Ribble Valley Borough Council  
Housing & Development Control

Application no: 3/2022/0282

Address: Stanley House Preston New Road Mellor BB2 7NP

Proposal: Illuminated V-shaped advertisement board on Preston New Road/Entrance to Stanley House.

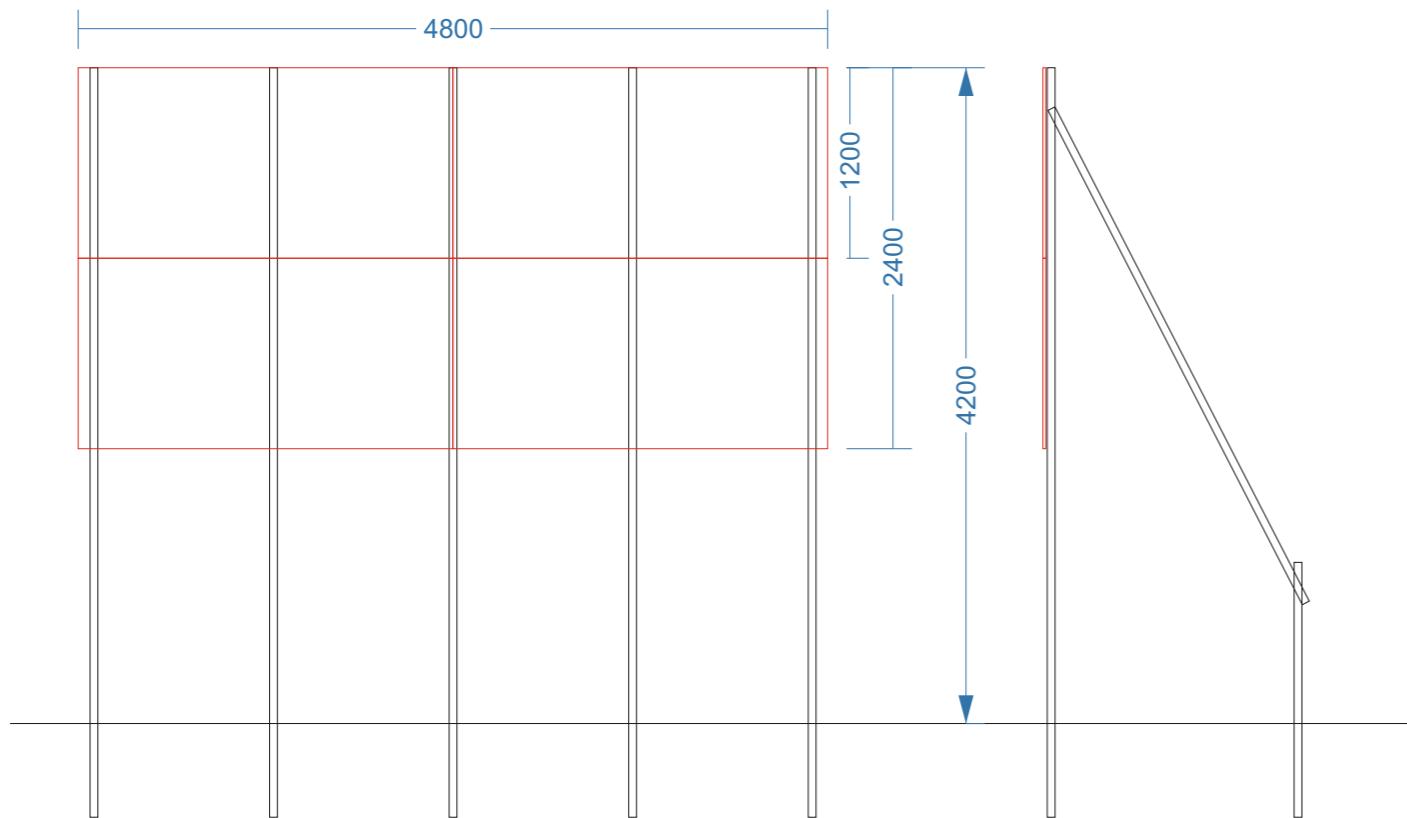
The LHA have reviewed the supporting documents and have no objection to the illuminated sign which will have the maximum illumination levels of 299 cd/m<sup>2</sup>, as stated on the Application Form, as shown on the Local Planning Authorities website.

The LHA will condition, to ensure that the illuminance levels do not exceed the maximum levels given the area of the site, that the maximum luminance of the light source shall not exceed 400 cd/m<sup>2</sup>

1. The maximum luminance of the light source shall not exceed 400 cd/m<sup>2</sup>.

REASON: To avoid glare, dazzle or distraction to passing motorists and pedestrians.
